VACATION OF INTERIOR LOT LINE MAP FOR ROLLING THUNDER BUSINESS PARK
LOTS 9 & 10

PEAK GYMNASTICS
PEAK GYMNASTICS & FITNESS
10611 MALTESE POINT
PEYTON, CO 80831
EL PASO COUNTY, COLORADO

Markup Summary

# VACATION OF INTERIOR LOT LINE MAP FOR ROLLING THUNDER BUSINESS PARK LOTS 9 & 10

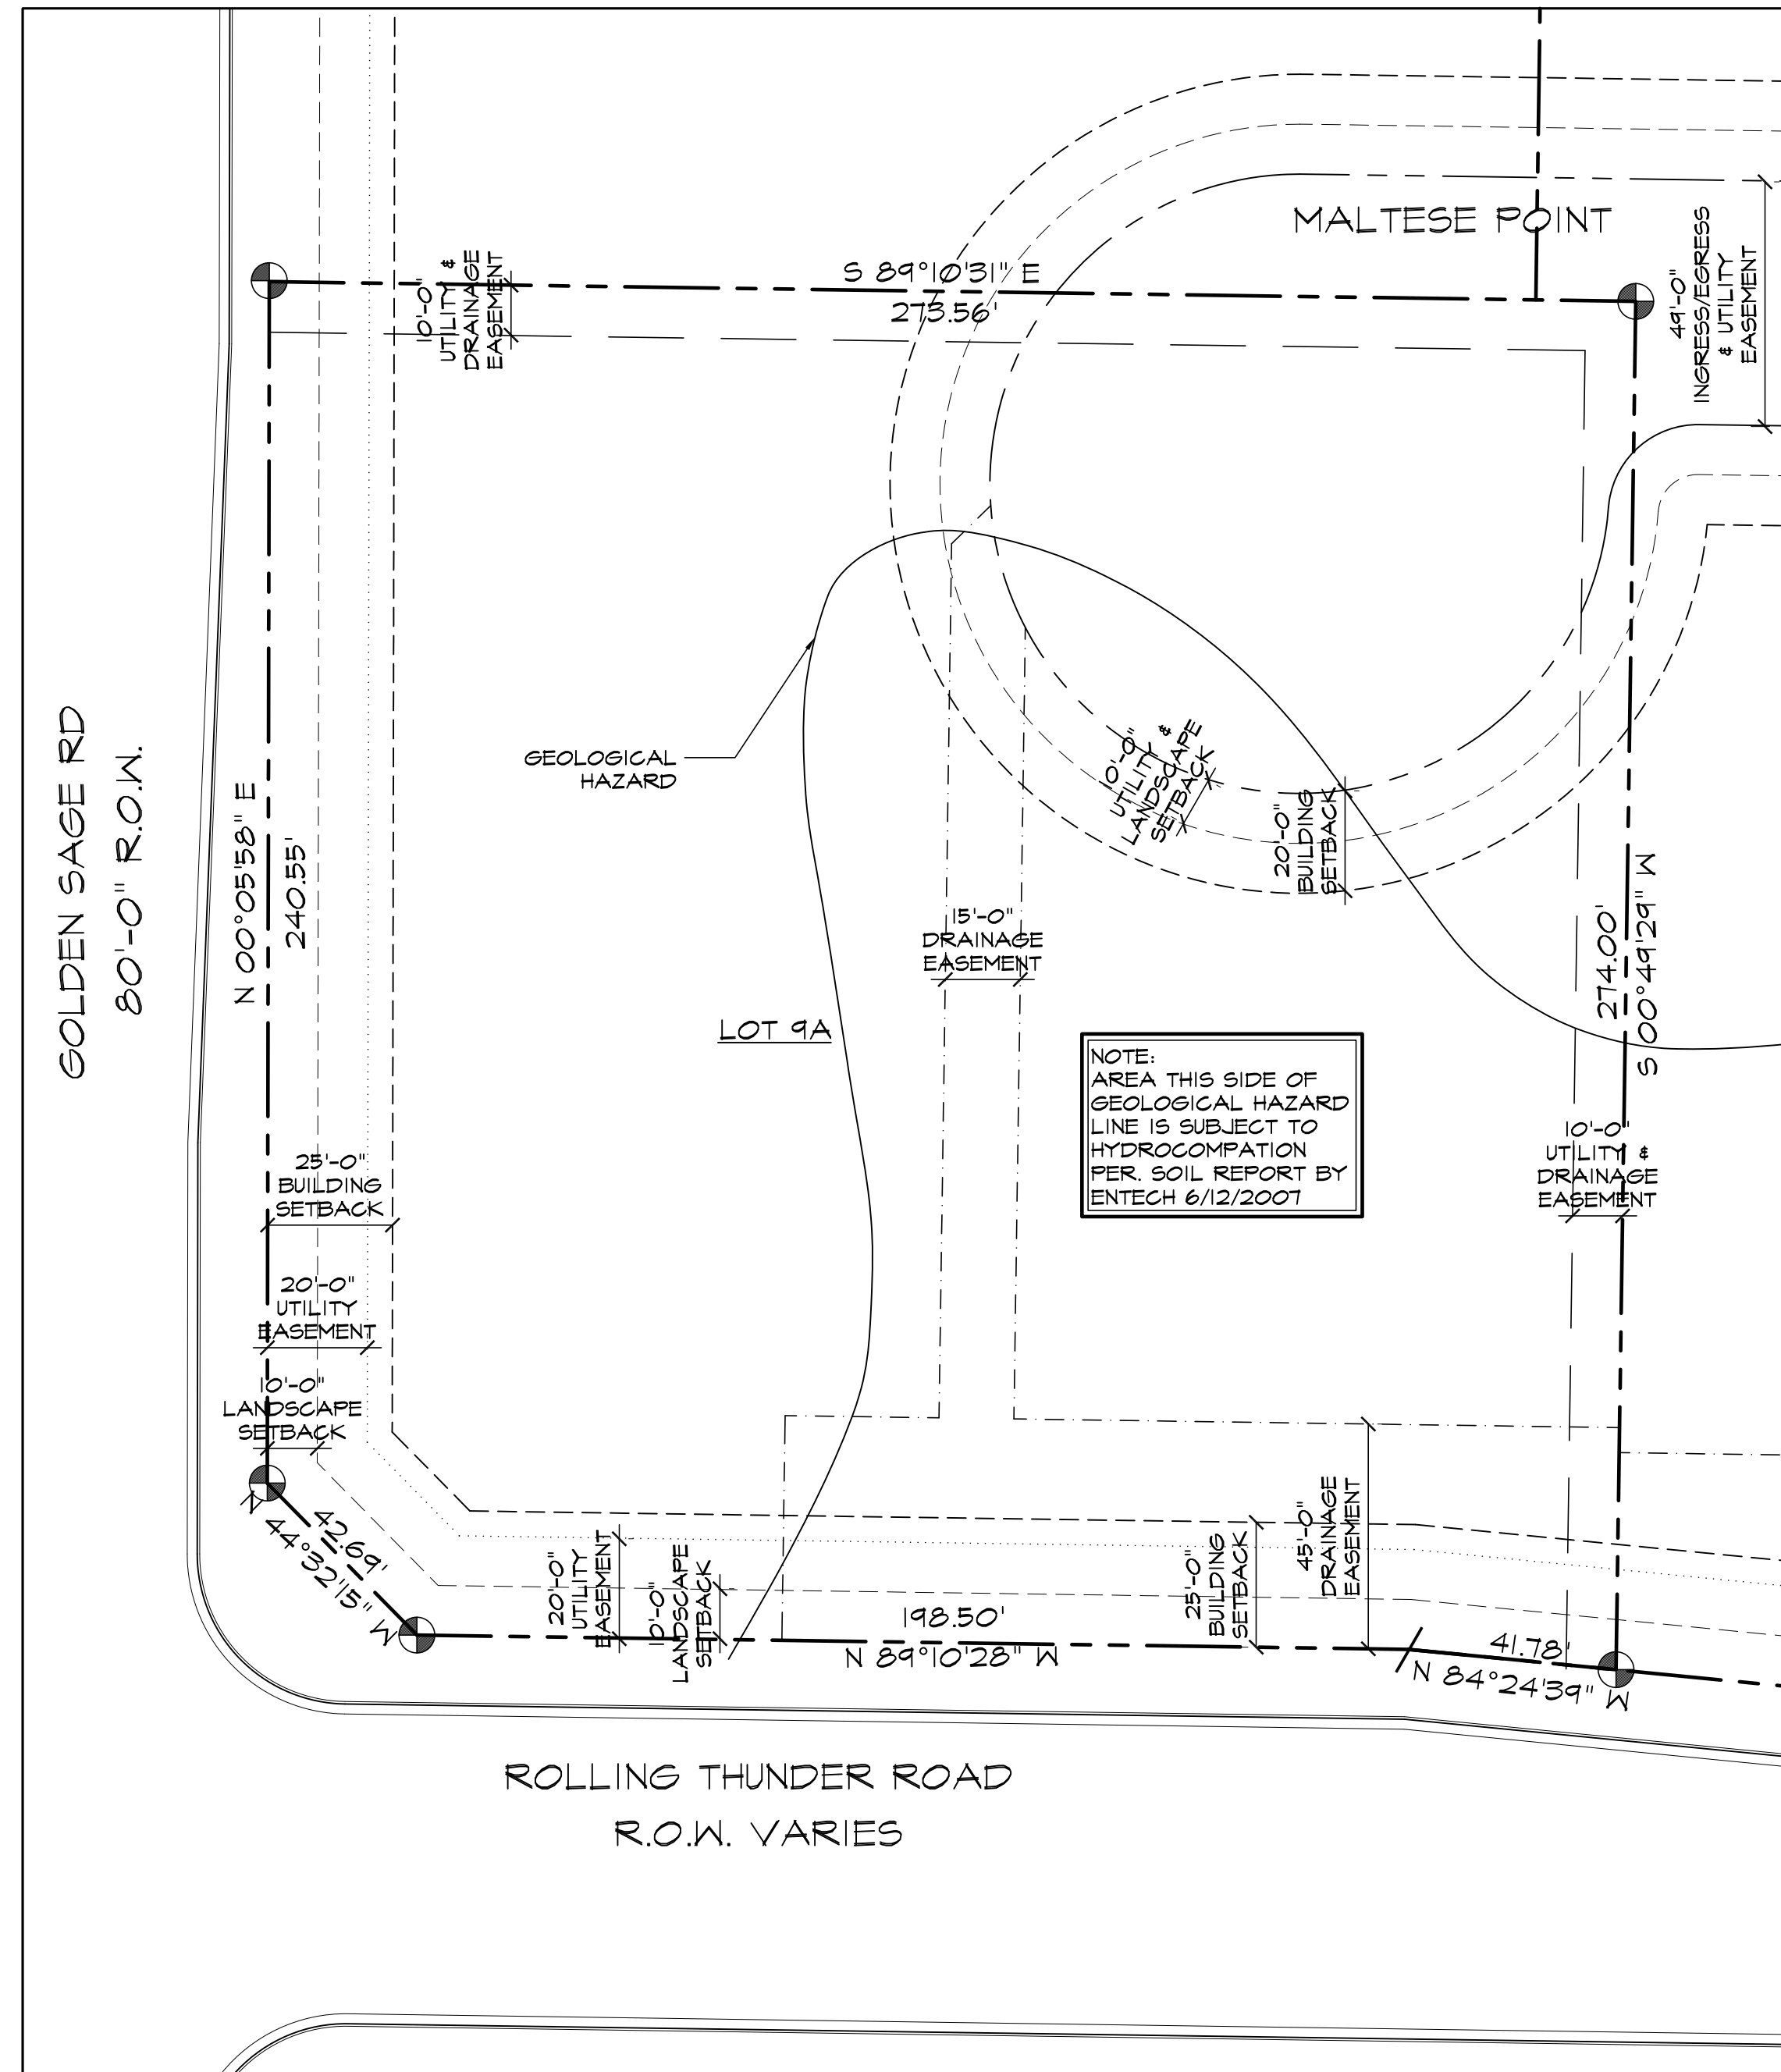
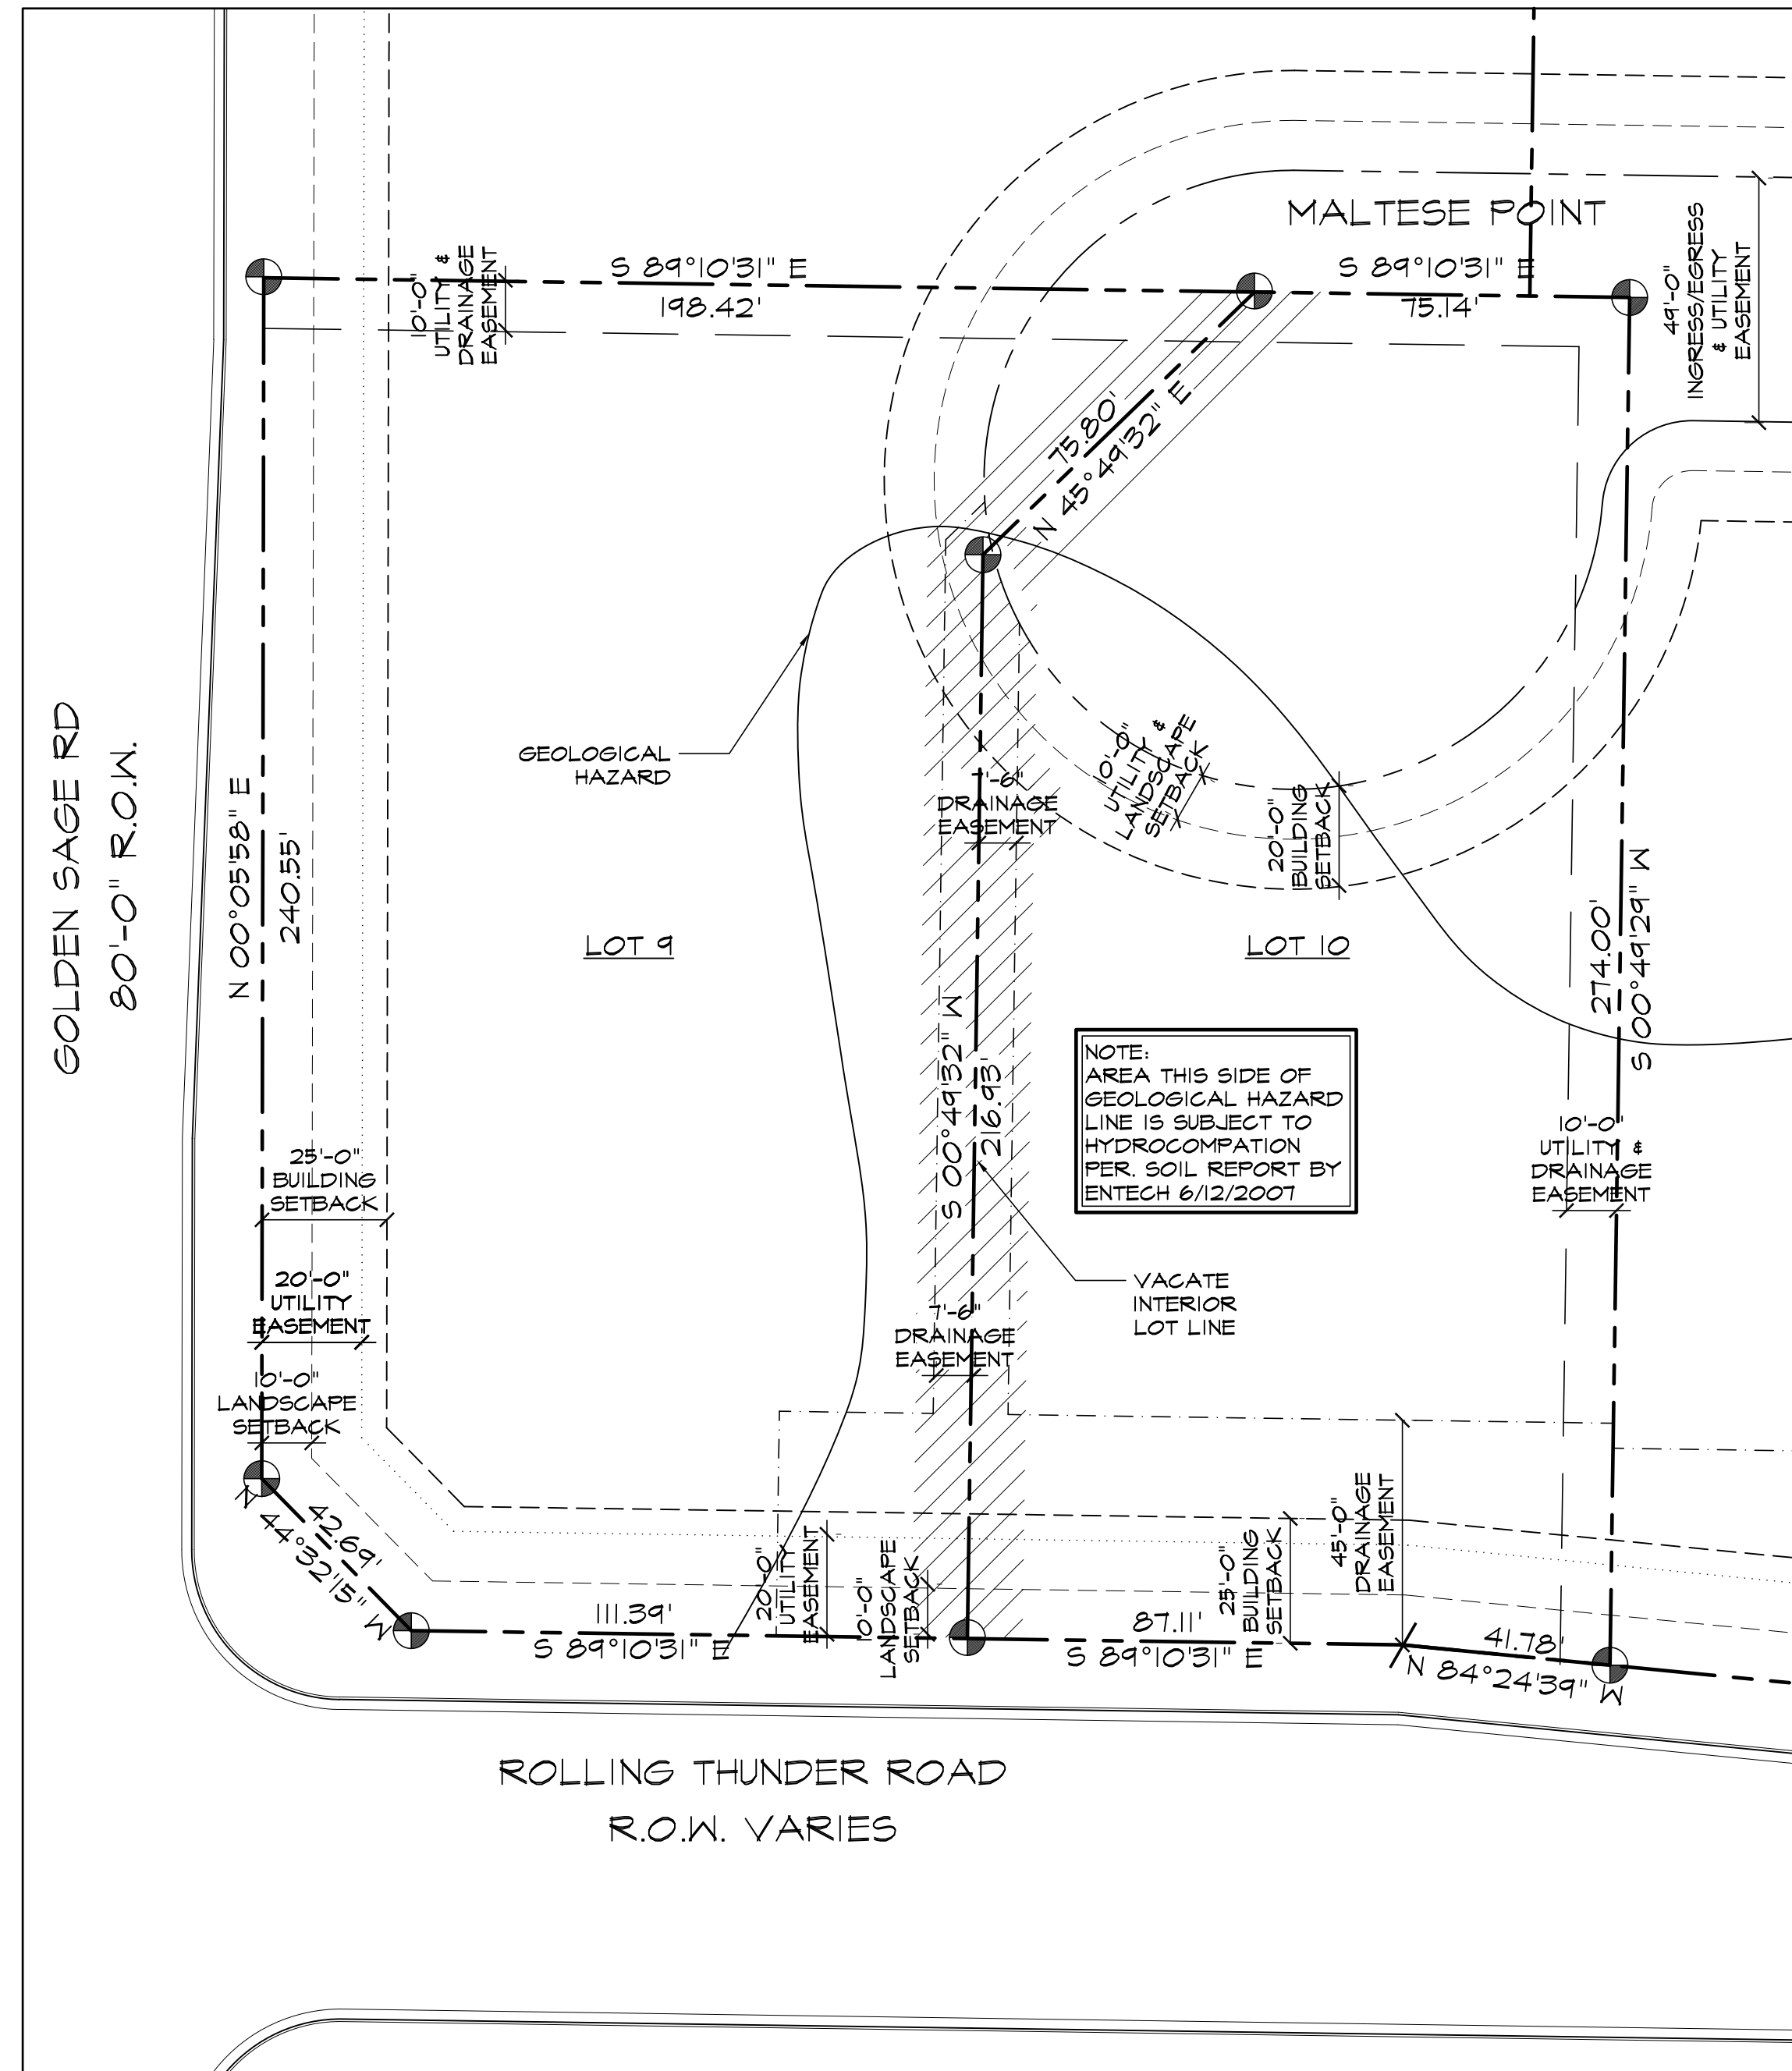
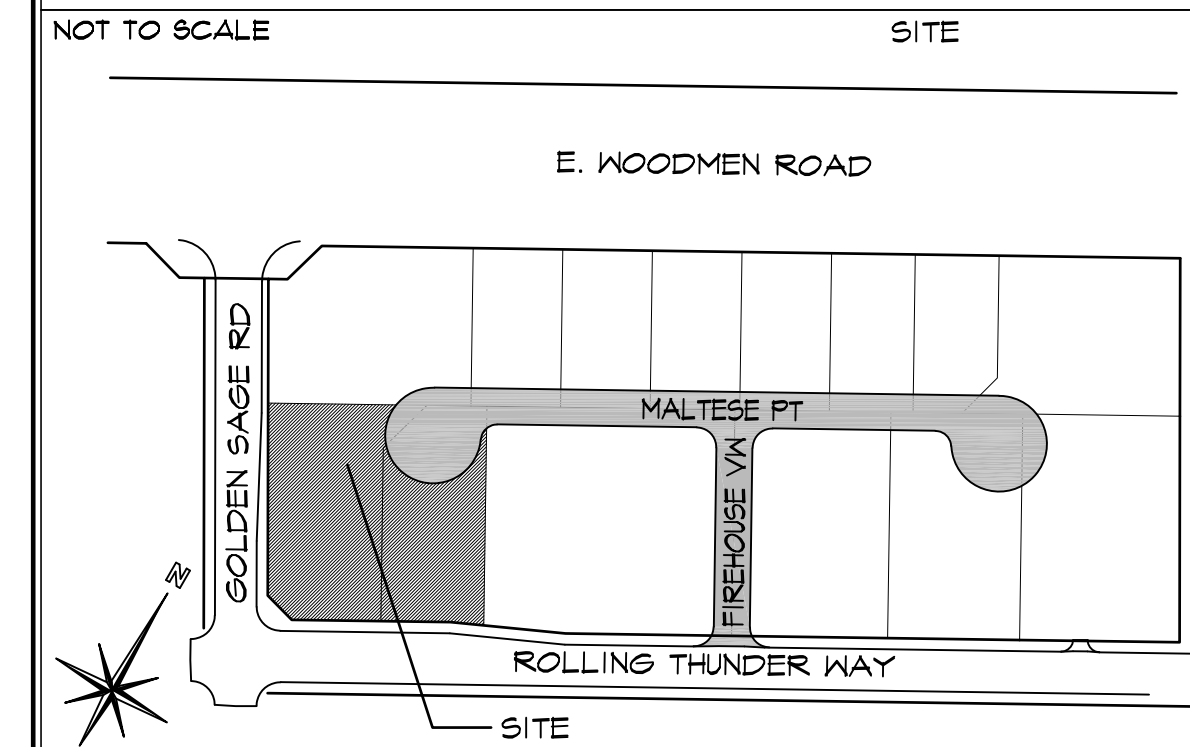
Remove the C&Gs.

Add "PCD V184"

Show the geological hazard area
